Landscape plans

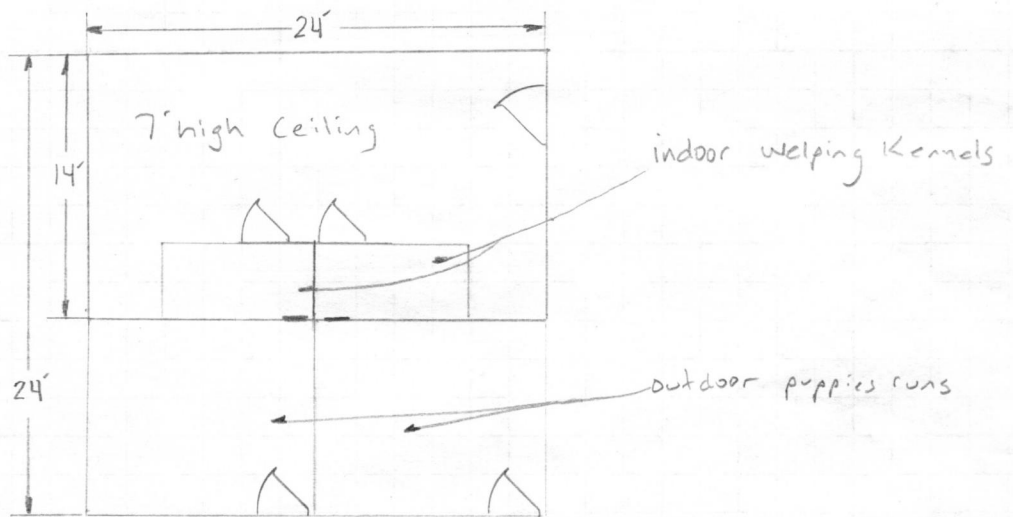
Not a Landscape plan. This needs to have a legend of what the plant or tree is, the required amount, then the provided amount. If you cannot meet the minimum of Chapter 6 of the Land Development Code, you must request an 'Alternative Landscape Design' in your letter of intent.

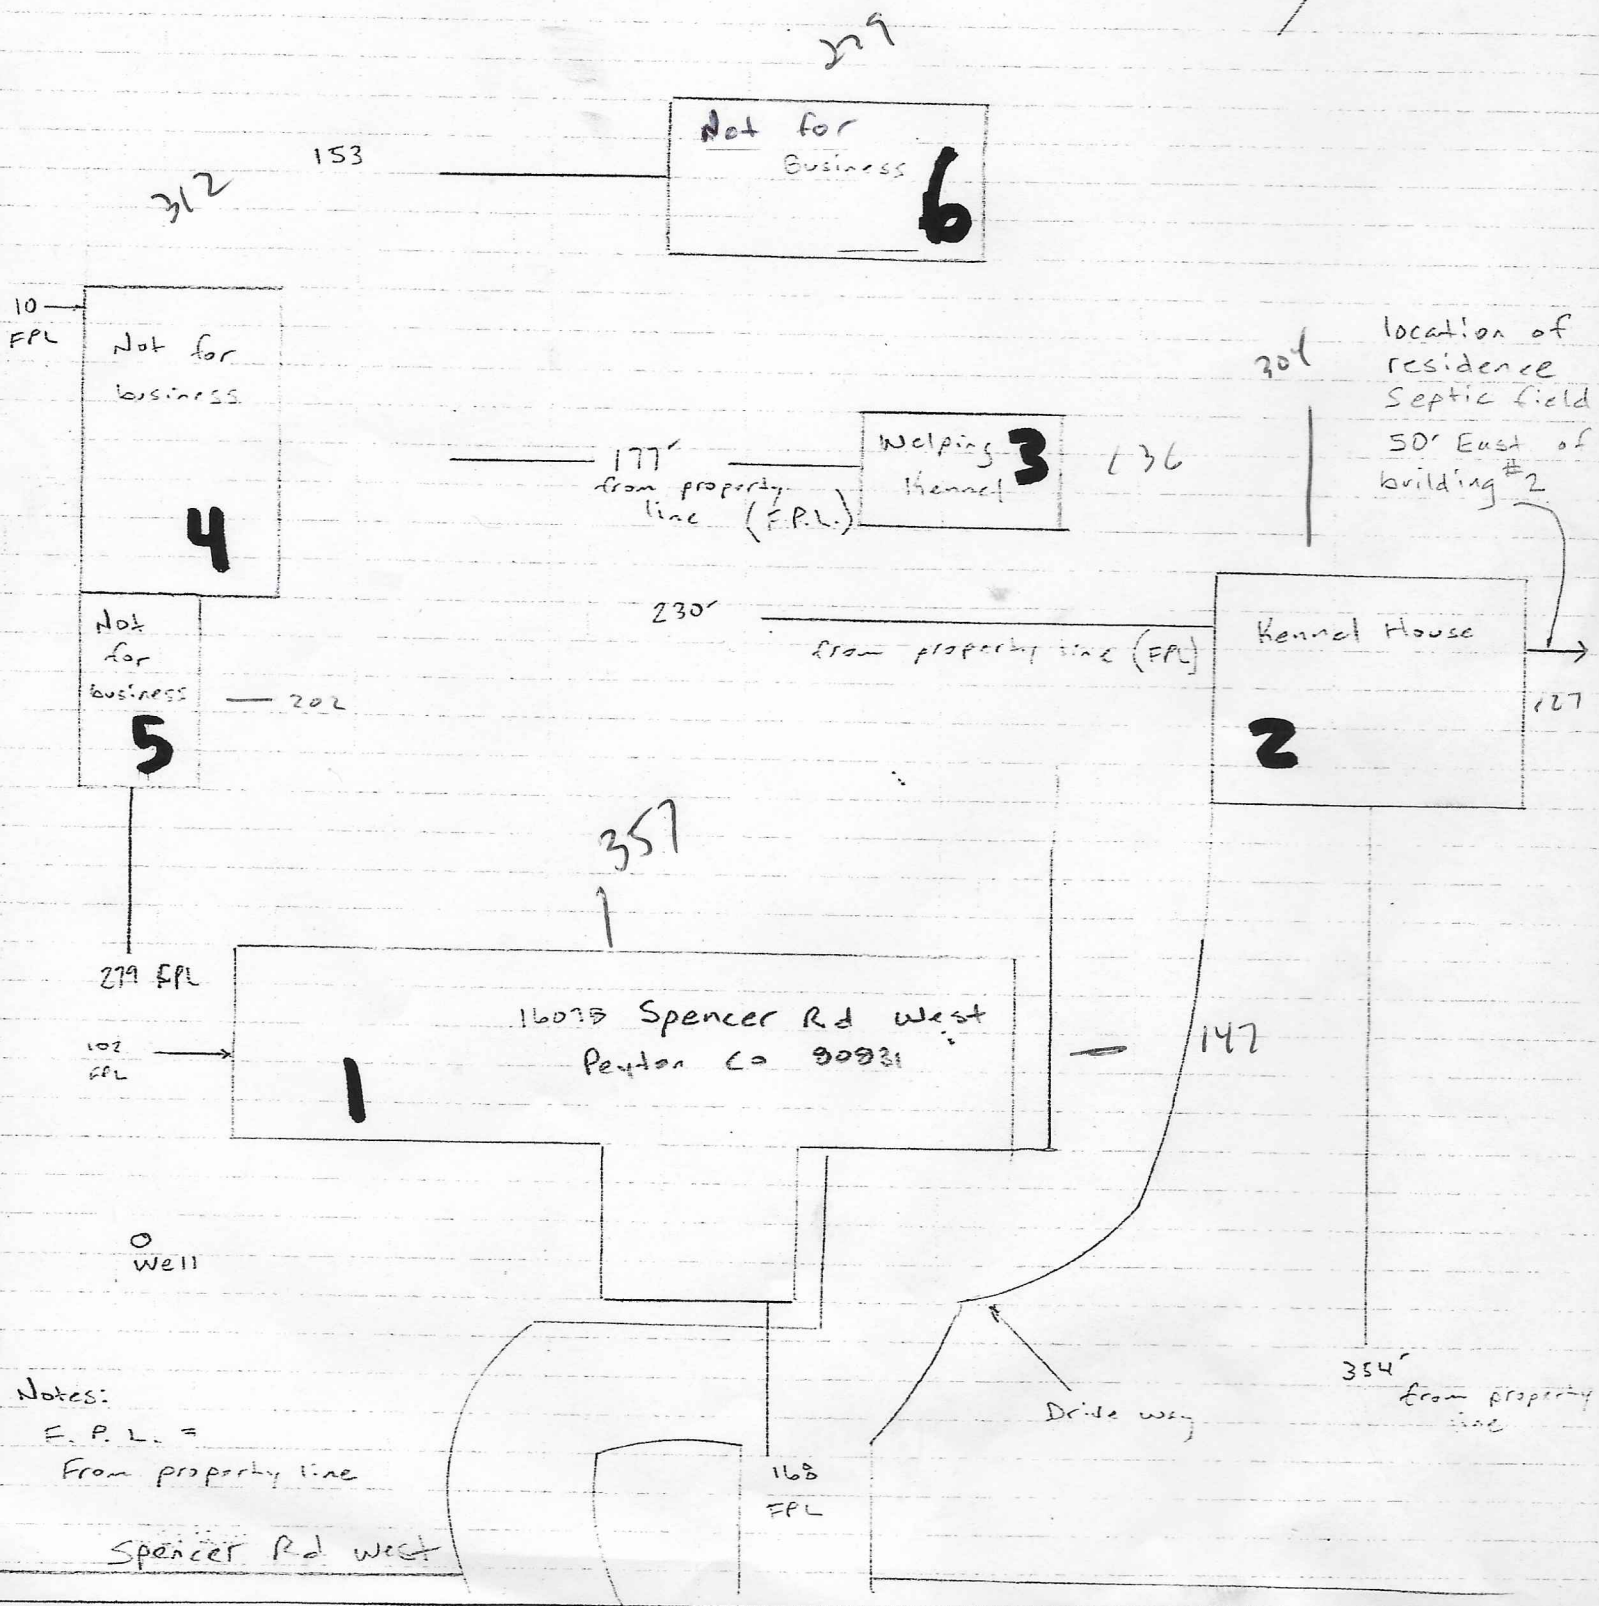
Show and label all existing structures on plan with dimensions to property lines. The letter of intent indicates that there are 4 outbuildings and 1 shed. Only 2 existing outbuildings are shown.

existing structure missing, please include and also in Letter of Intent state it will not be used in relation to kennel operations

Show Spencer Road on plan with the existing access/driveway to the property.

Add PCD File No. PPR1855
